File No: R/2014/21
Our Ref: 2014/377776

RE: SSD 6069 – Walsh Bay Arts Precinct Stage 1 Concept DA

This submission comprises the City of Sydney's (the City's) comments on the proposed public domain, heritage, transport and environmental issues associated with the Stage 1 DA.

Figure 7.4.2: Current revised design improved to reduce the overall size of the square while emphasising the central performance space as projecting into the water. The blue arrow shows central projection in line with the ground floor breezeway on Pier 2/3.

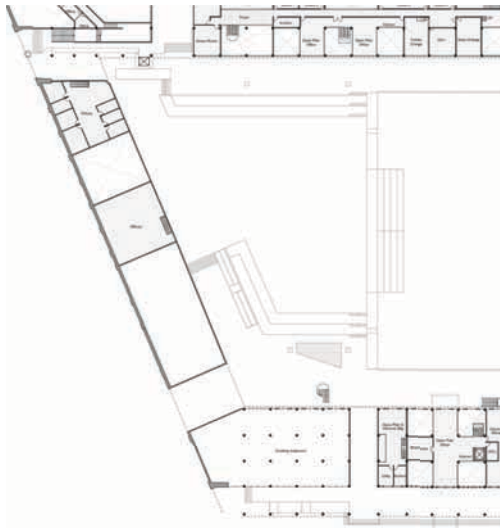
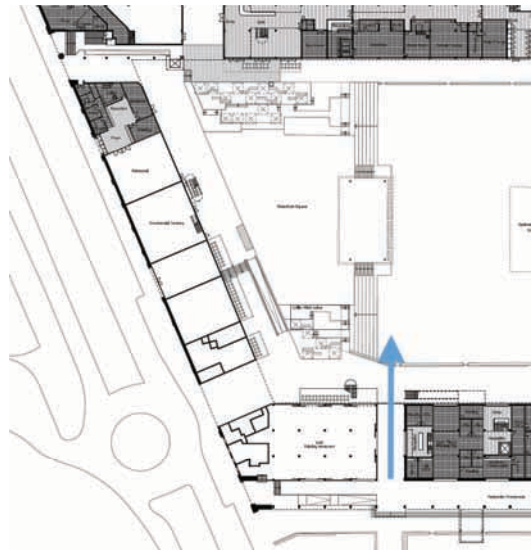
- The design of the Waterfront Square being subject to further development and detail to reduce impact. This is to include adequate delineation of aprons and the square through measures such as the use of different materials. The cover needs to be sympathetic and respectful of the industrial character of the place as well as being a design of high quality;

Figure 8.4.4: Existing photo of Pier 2/3 (left) and photomontage (right) showing the likely appearance of raised roof for ACO auditorium and solar array on Pier 2/3. Image taken from the Harbour Bridge, bicycle path

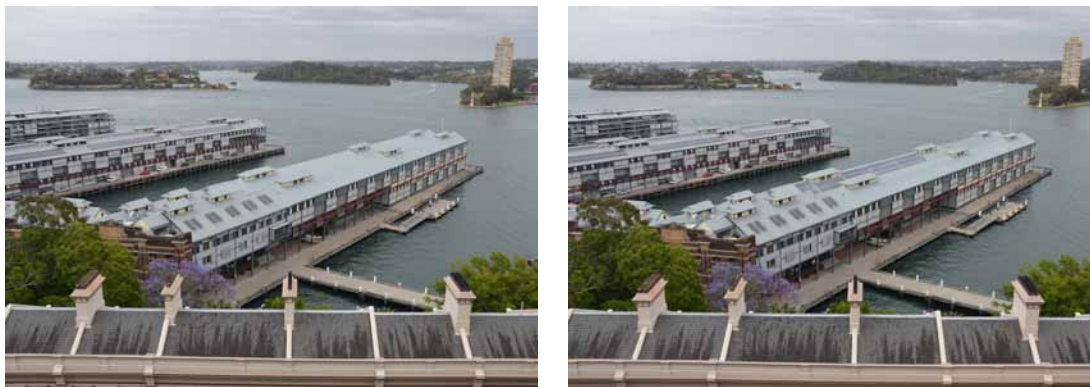
- Removing the detracting skylight on the external slopes of the south end of Pier 2/3; and
- An External Signage Strategy being prepared that ties in with the signage within the rest of the precinct.

Figure 9.2.1: Diagram showing opportunities and constraints for the Commercial Arts/Events Space.

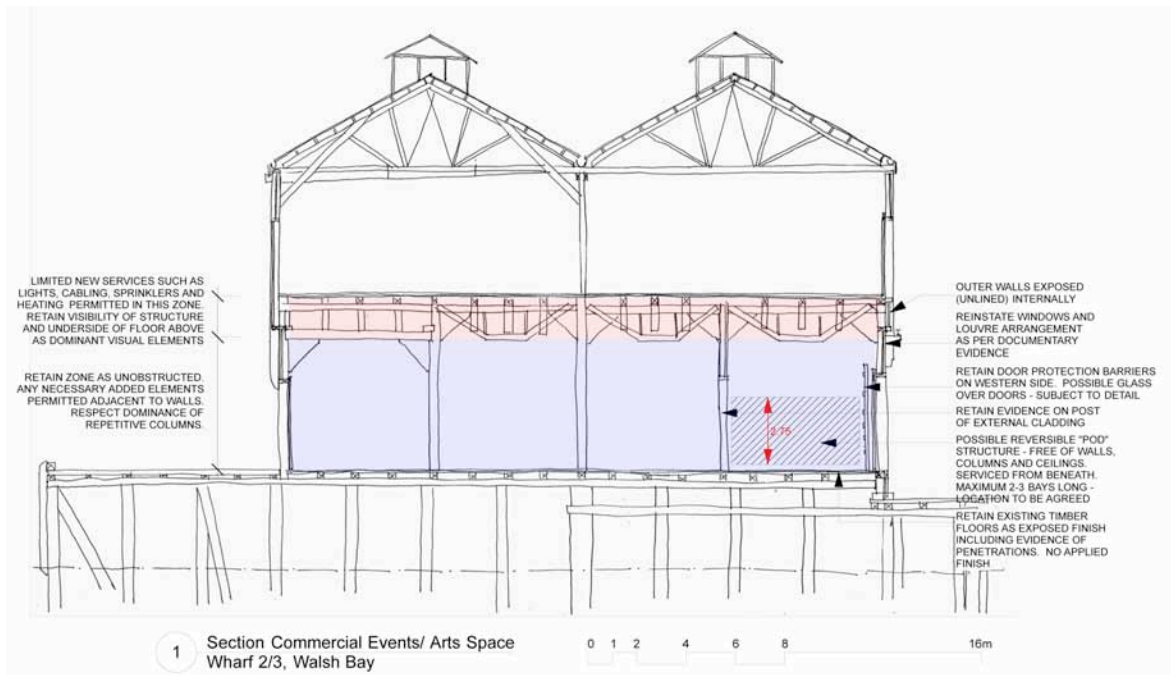
- The Commercial Events/Arts Space be designed such that all amenities and ancillary rooms are reversible and the full height and openness of the space being retained, with any partitions or screens to be temporary and not appearing permanent. The space should be not be modified to accommodate a fully controlled air-conditioned environment;

Pier 2/3 Existing East Elevation

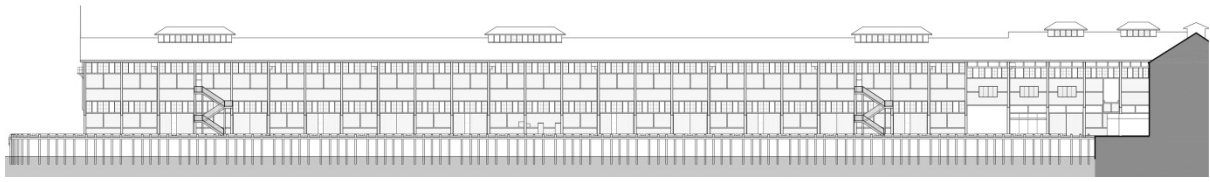
- Investigate the least-impact option in relation to opening up the northern most bay on the east and west elevations of Pier 2/3 - altering existing weatherboards to become adjustable louvers, which will be open most of the time, will have a high visual impact;
